Pre-Application Meeting (PRE20-027)

Site Location:	ROW at 8215 SE 78Th ST (MIV 43)		
Lot Size:	N/A	Zoning:	R-9.6 (Single Family)
Brief Project Description:	Proposal for a new small cell facility in the public right-of-way on a new 46'-0" wood pole	Documents Provided:	<ul style="list-style-type: none">• Code Compliance Narrative prepared by Crown Castle, no date• Development plan set prepared by Morrison Hershfield, dated May 20, 2020• ROW survey prepared by Kevin J. Walker, PLS, dated April 8, 2020• Permit #1906-107
Applicant Information:			
Name:	Amanda Nations, Crown Castle	Email:	amanda.nations@crowncastle.com
		Phone:	206-778-1548
Second Pre-application Meeting Required:	Not Applicable	Click for explanation if necessary

SHEET NUMBER
SV1

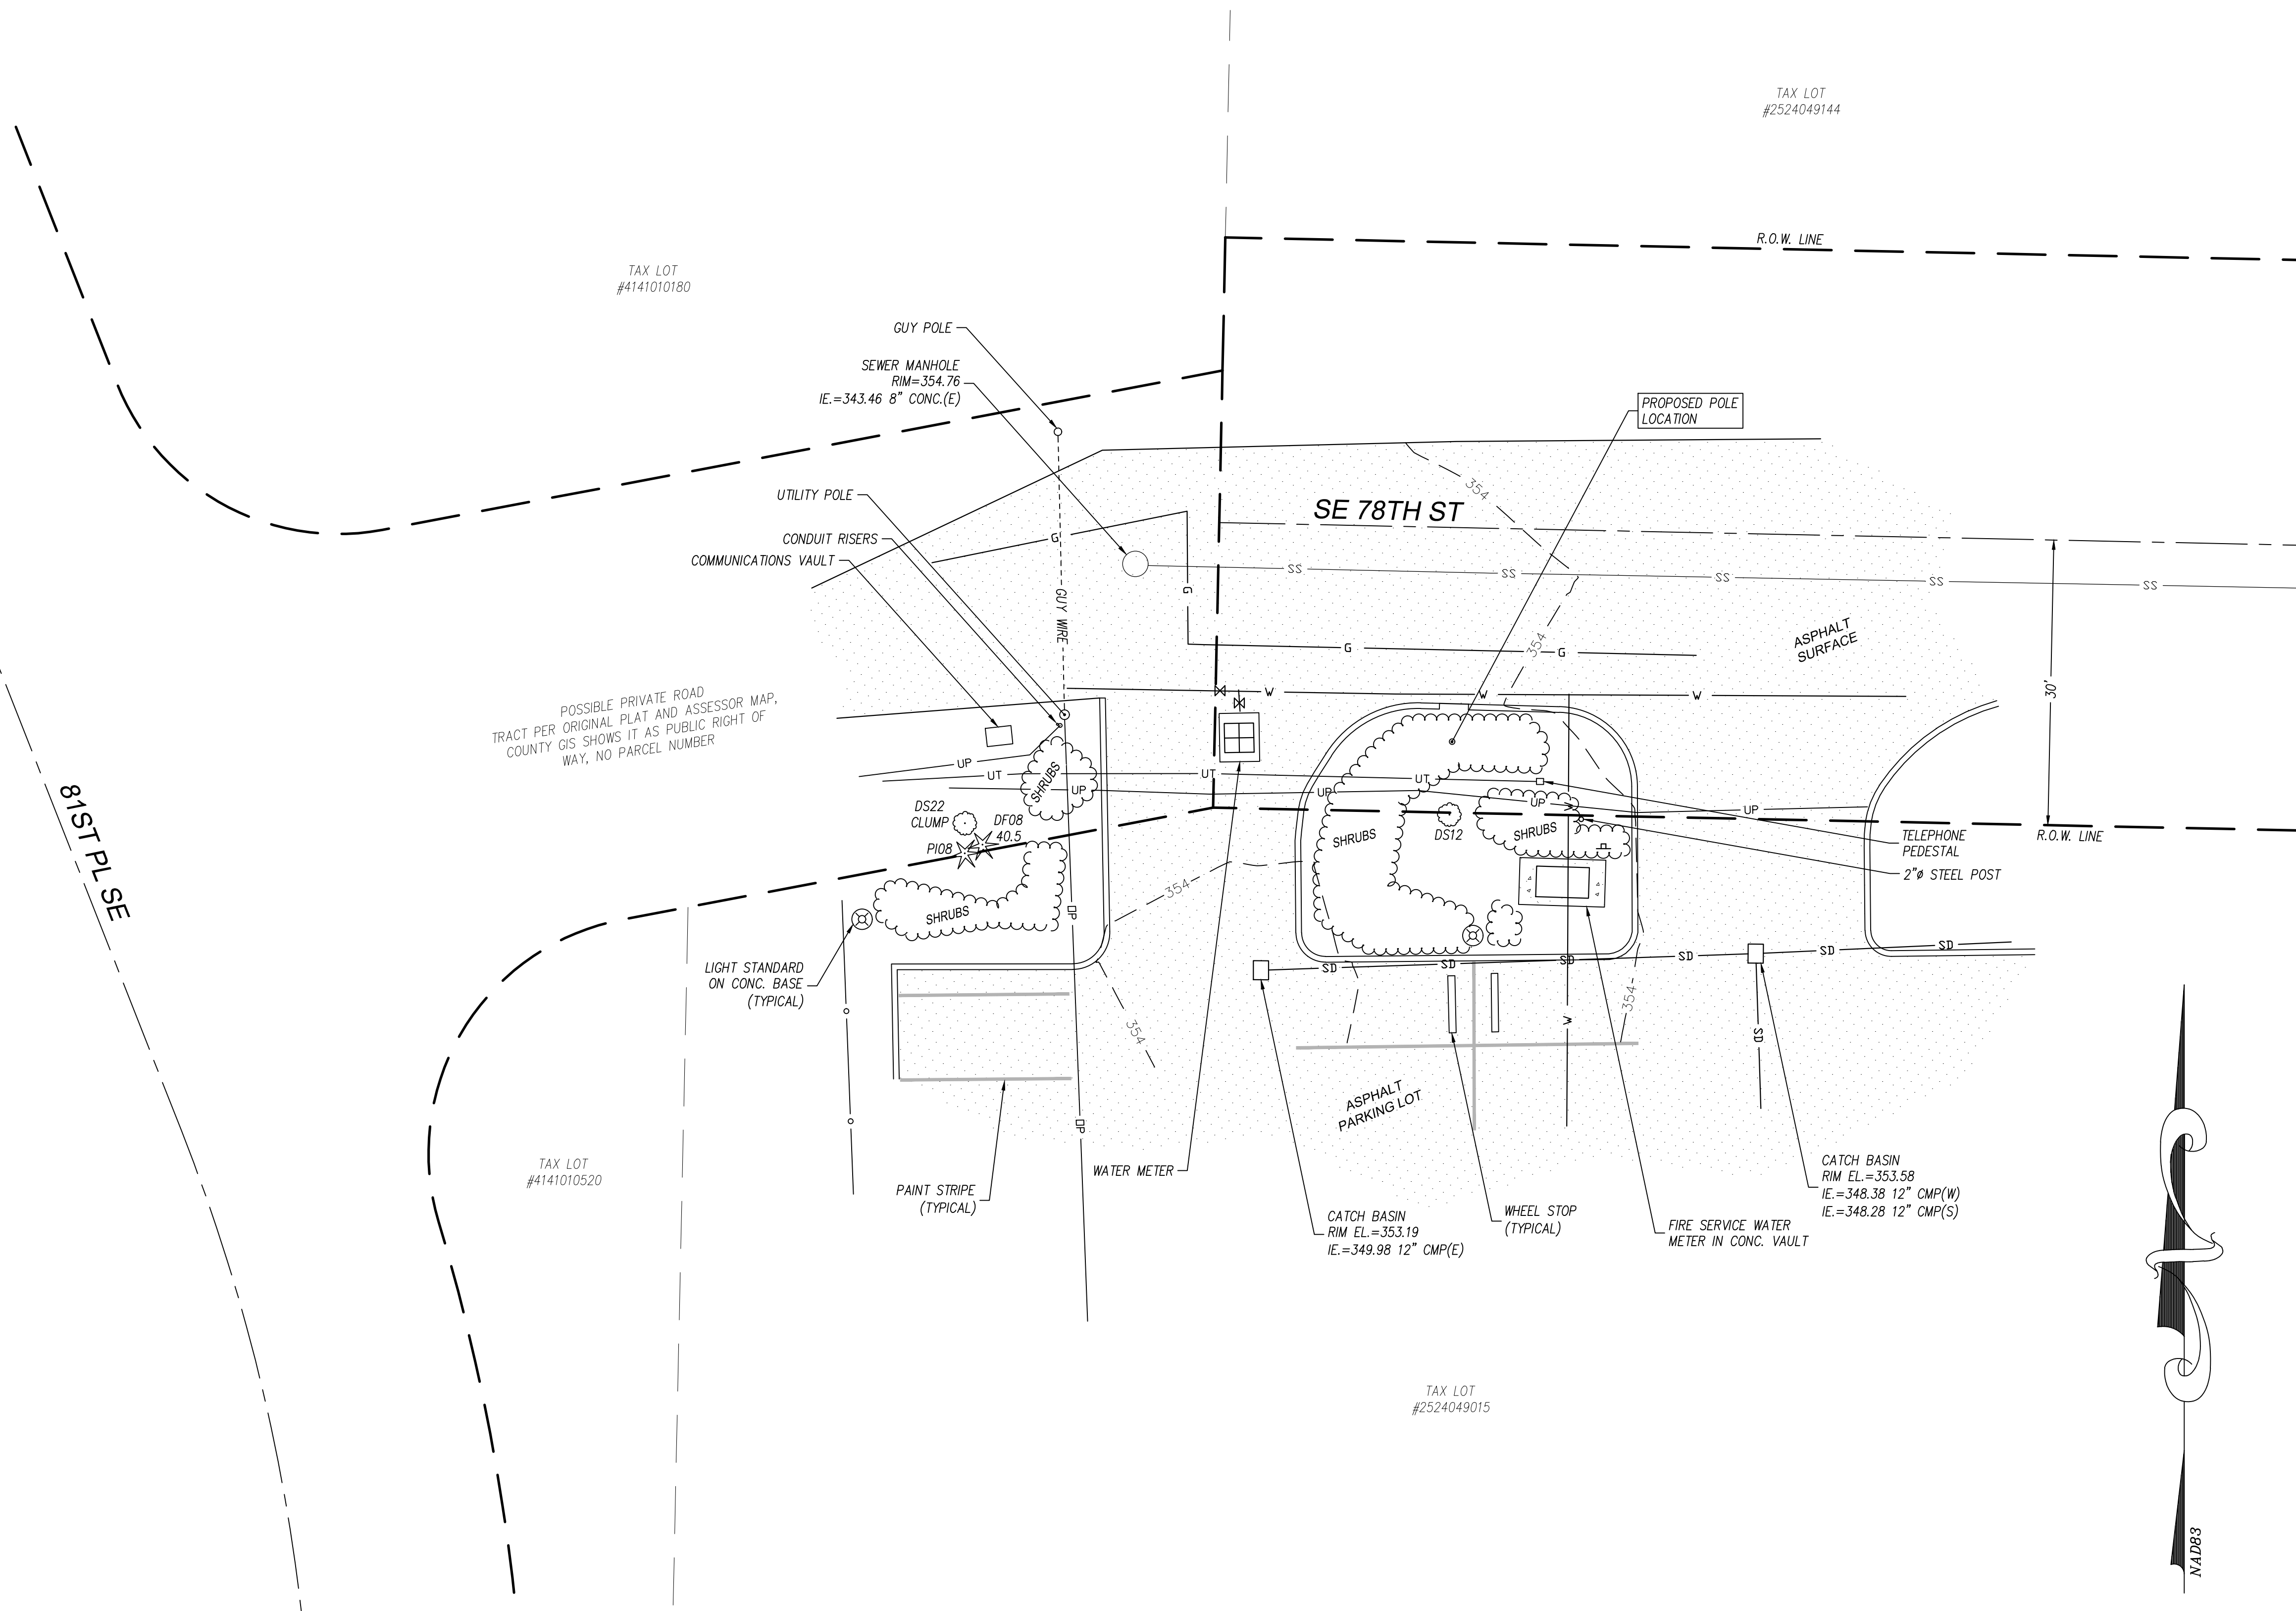
1. New poles generally need to be installed at least 10 feet away from the City water mains. The survey provided shows the water main 5 feet from the water main. However, the proposed location may be permissible if a minimum 5-foot clearance between the pole and actual pothole location of the water main is provided.
2. Pursuant to MICC 17.14.010 Section 105.2, a building permit for wireless communications facilities located in the public way is not required. At the request of the City Engineering Division, the Building Division will provide a structural review of the proposed construction. Please provide all information necessary to perform a complete structural review, including design criteria, justifying structural calculations, and other supporting information as necessary.

22"x34" SCALE: 1" = 20'-0"
11"x17" SCALE: 1" = 40'-0"
SITE PLAN 1

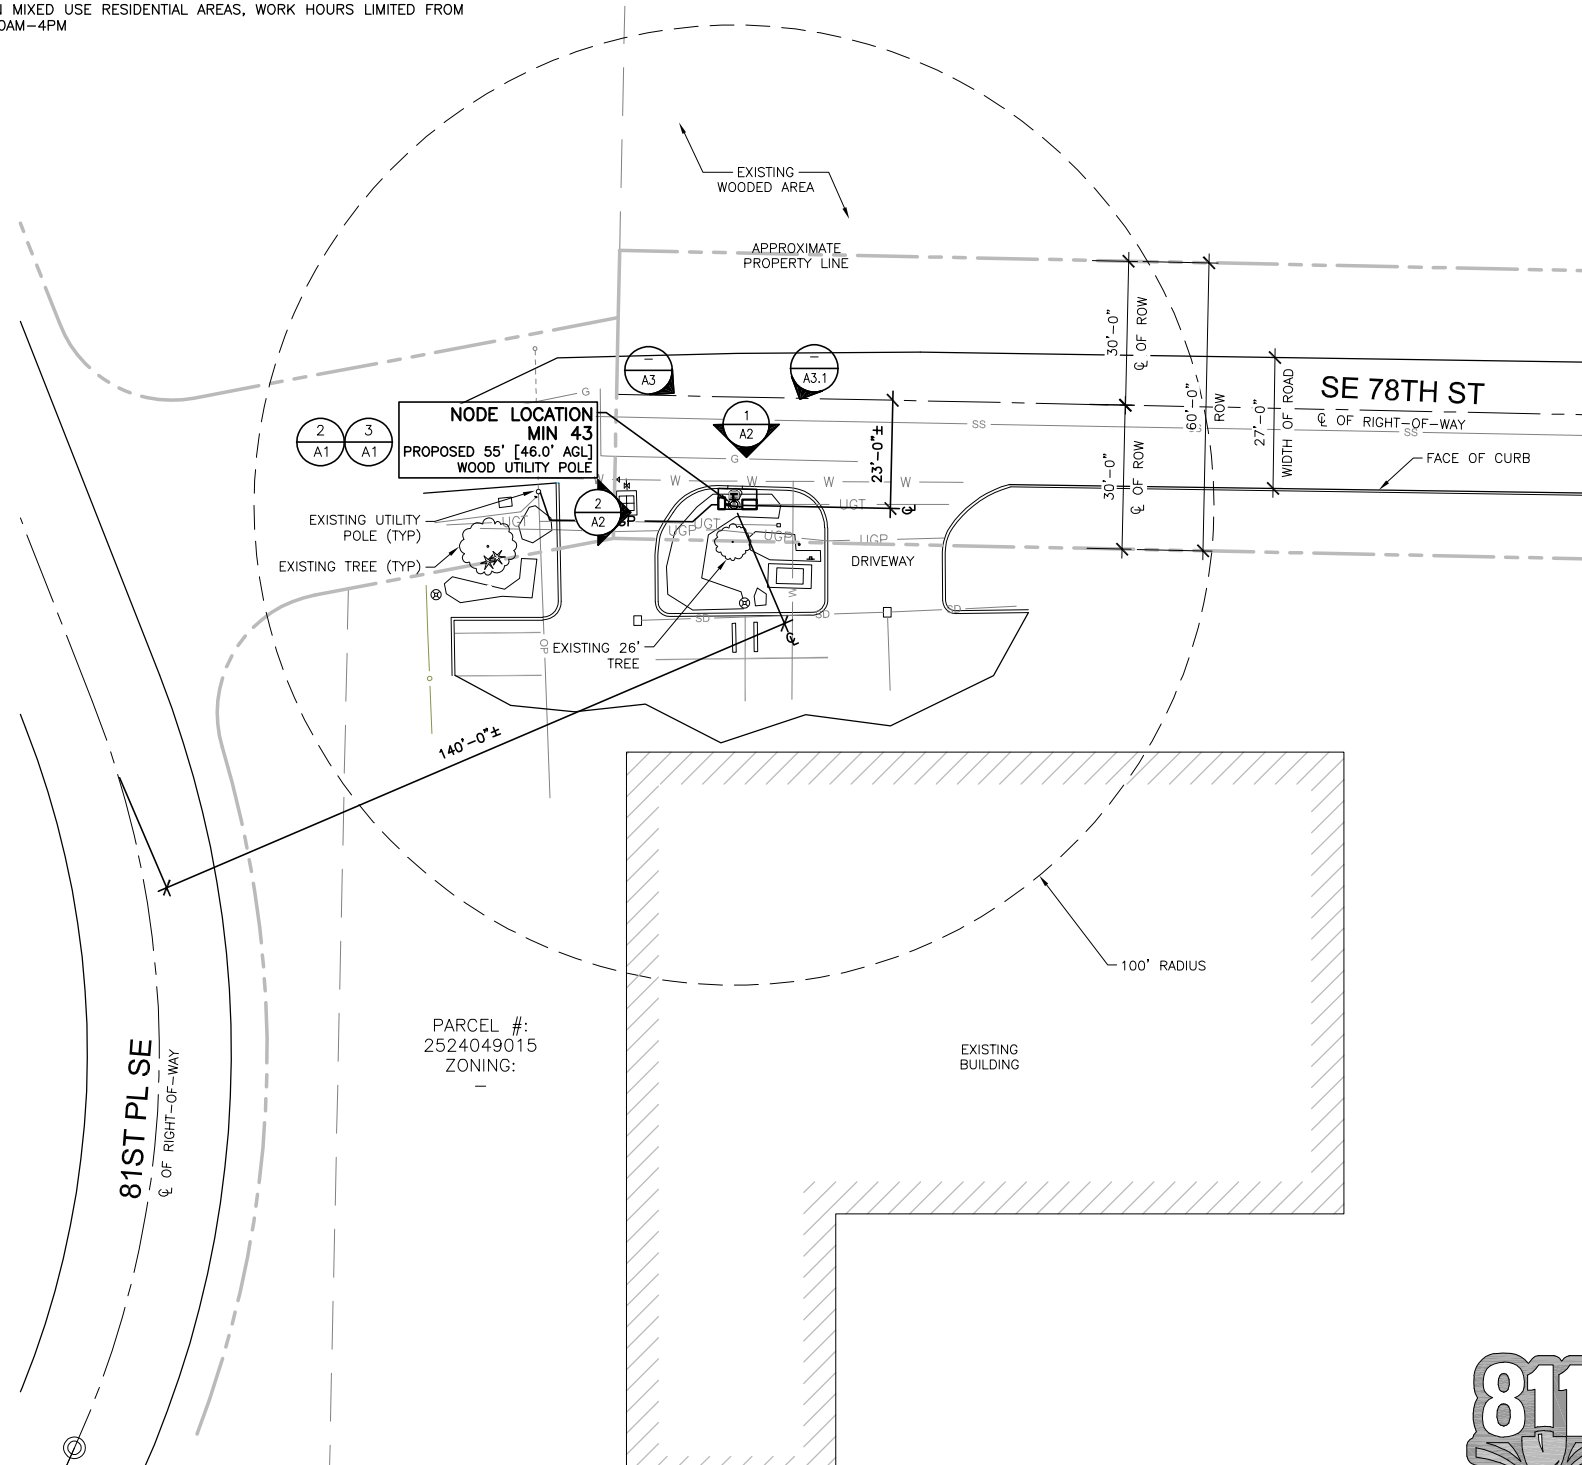
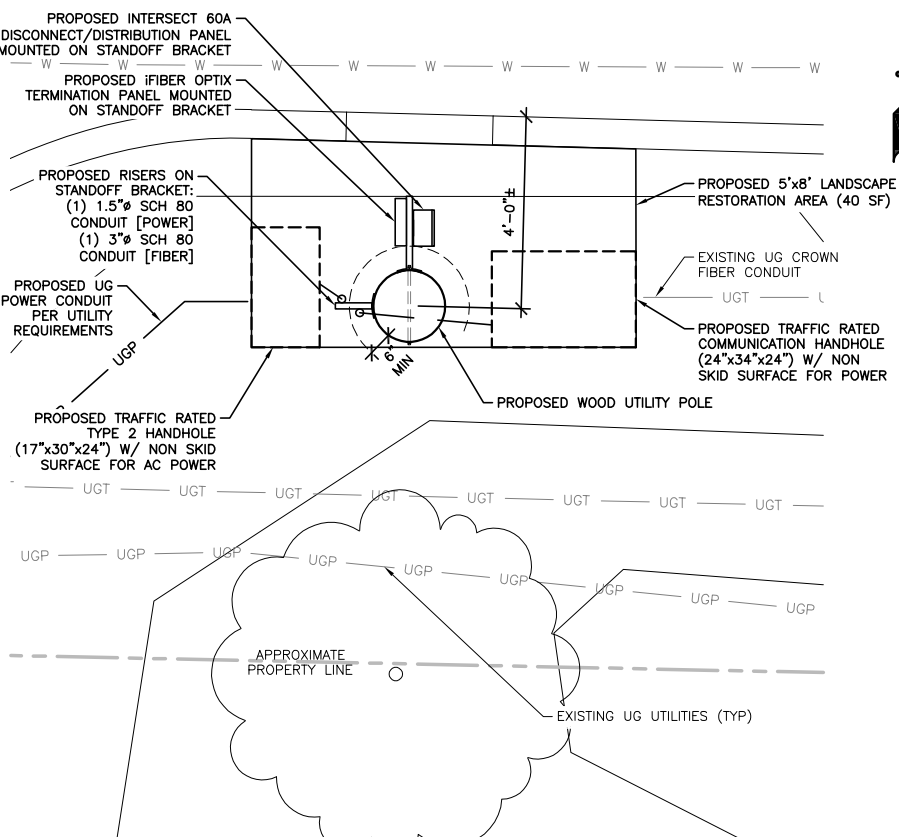
5. Please refer to MICC 19.10 for our tree code.
6. The proposed location appears to conflict with a city tree. Please investigate if it is possible to move the pole across the street where city trees will be not impacted. Alternately, please complete an analysis of construction impacts by a Qualified Arborist showing no long-term damage to the existing city tree.
